Subject: RE: LU/134/21/PL & LU/135/21/L The Farm, East Street, Littlehampton

Martyn White
Principal Conservation Officer,
Planning Services

In response to your comments on these DOC applications online (attached), please find attached photos and our comment to each of your points.

Drawing Name	Elevations - Proposed
--------------	--------------------------

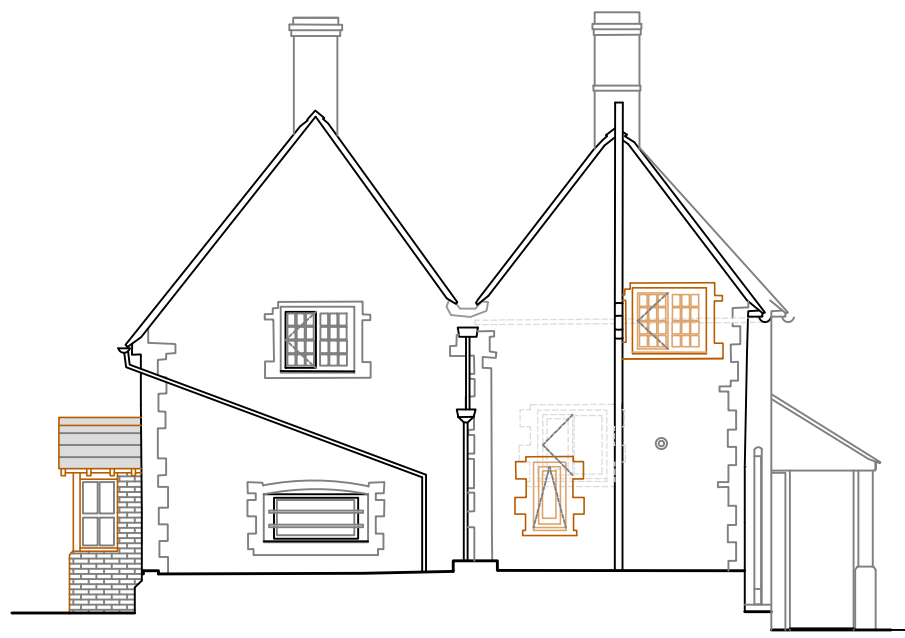
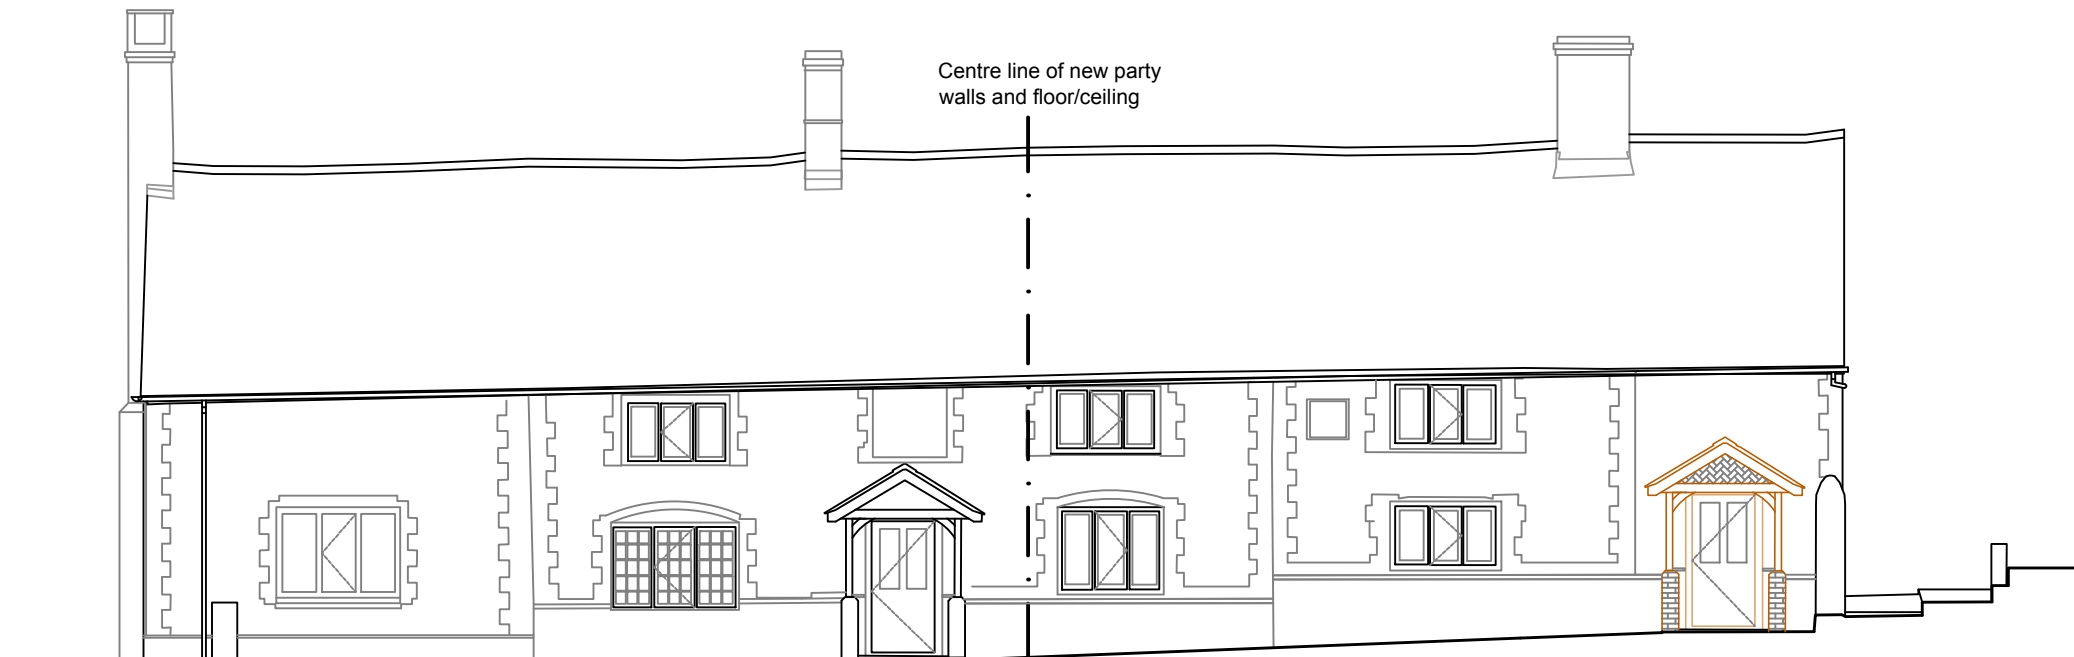
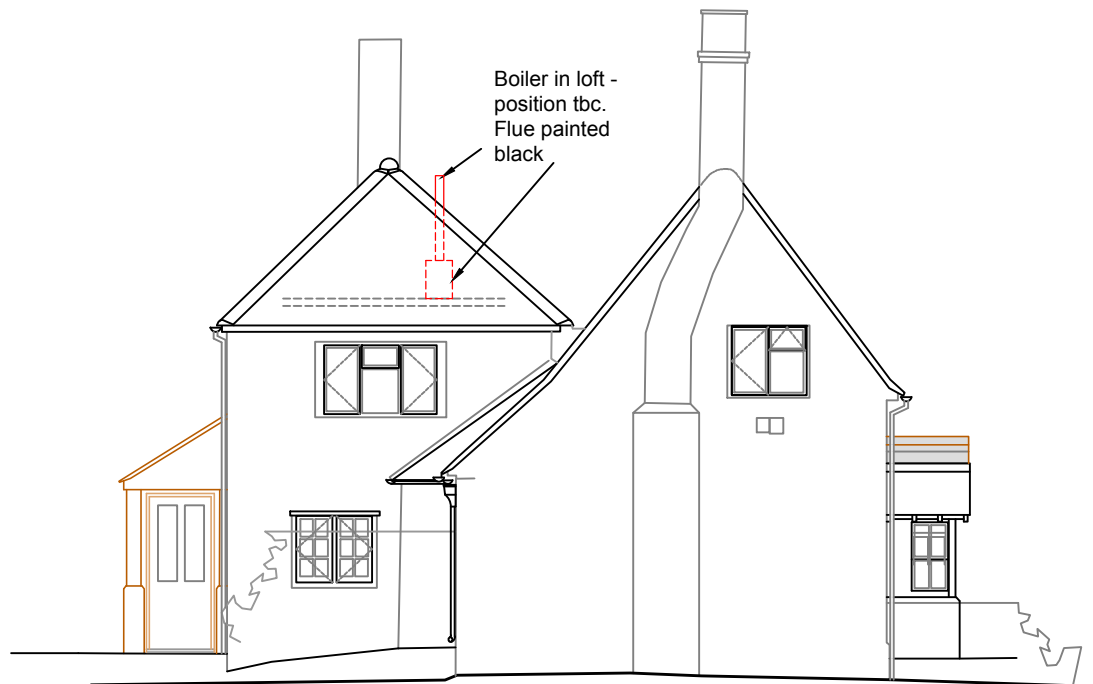
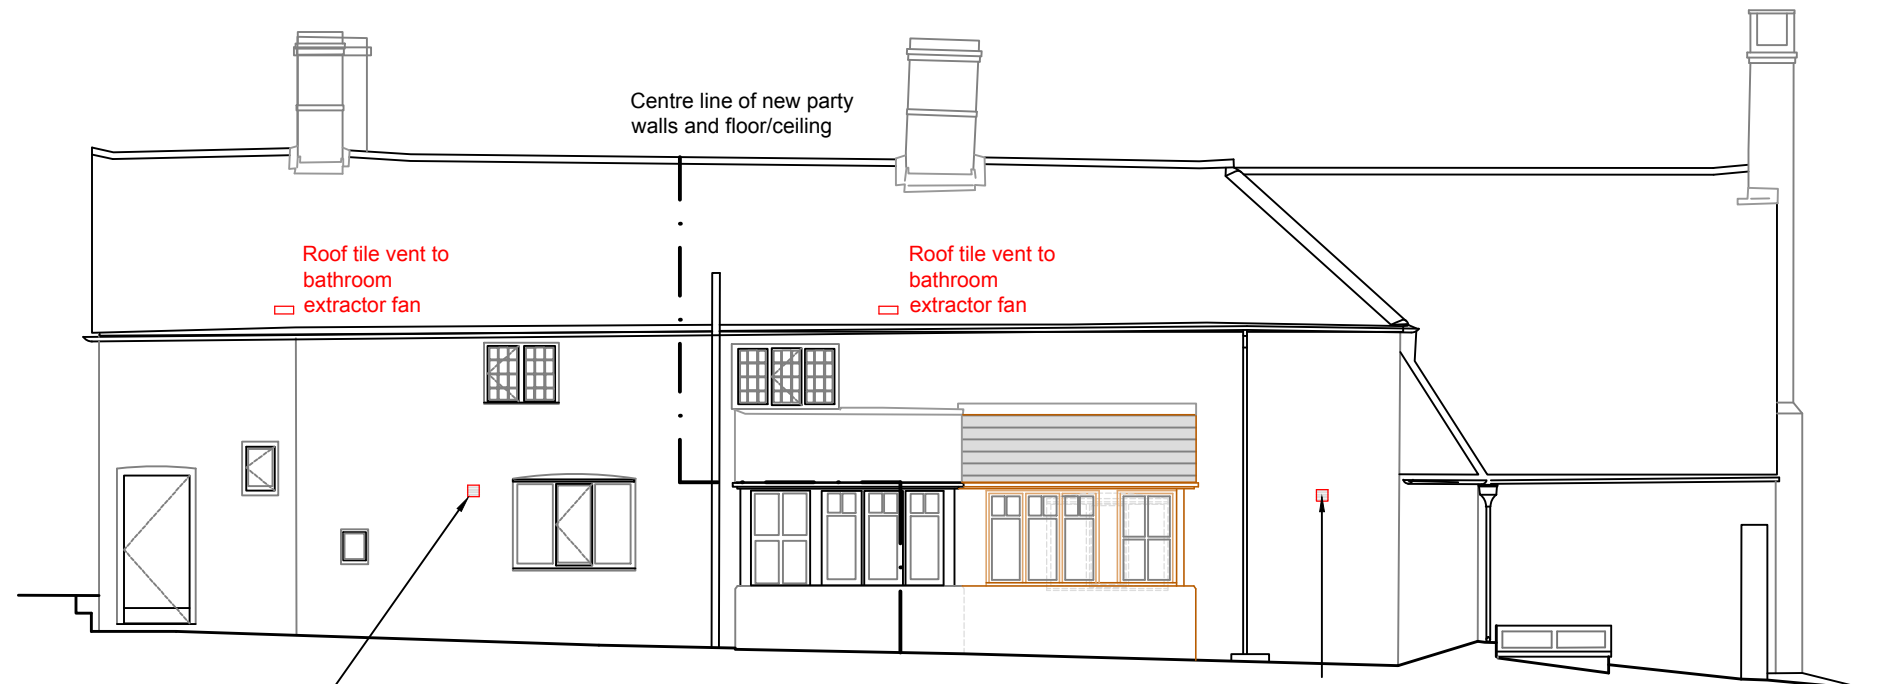
1. W10 Folder – These pictures are of the current porch for reference (W9) this is to be built as like for like as possible. If it truly going to be like for like it should be ok. Ideally, this would be confirmed with the relevant drawings

2. W6 Folder – This is the current GF wetroom window – needs to be removed and new top hung opaque window installed. Does this suffice or do we need to provide a sectional drawing? Ideally, yes. Would it be flush?

3. W16 – These pictures are of W15 for reference – this is to be like for like however not a Sussex pin window and will be a hinge window – picture of W13 for reference for hinged window. Does this suffice or do we need to provide a sectional drawing? We would want to make sure it is a suitable replica for the LB, and at present two photographs provided by the applicant show slightly different windows e.g. in one the glass is flush with the front of the frame, and in the other it is recessed. Which is correct?

5. W11. – Not shown as to be replaced. On closer attention may need replacing like for like. Do we need to update the plan to reflect this? And if stated like for like will there need to be any further information to support this? Ultimately, we would need to understand what the replacement window will look like if it is needed. I personally would say that the easiest thing to do would be include it on the plans and then there is no need to request permission from us to replace it.
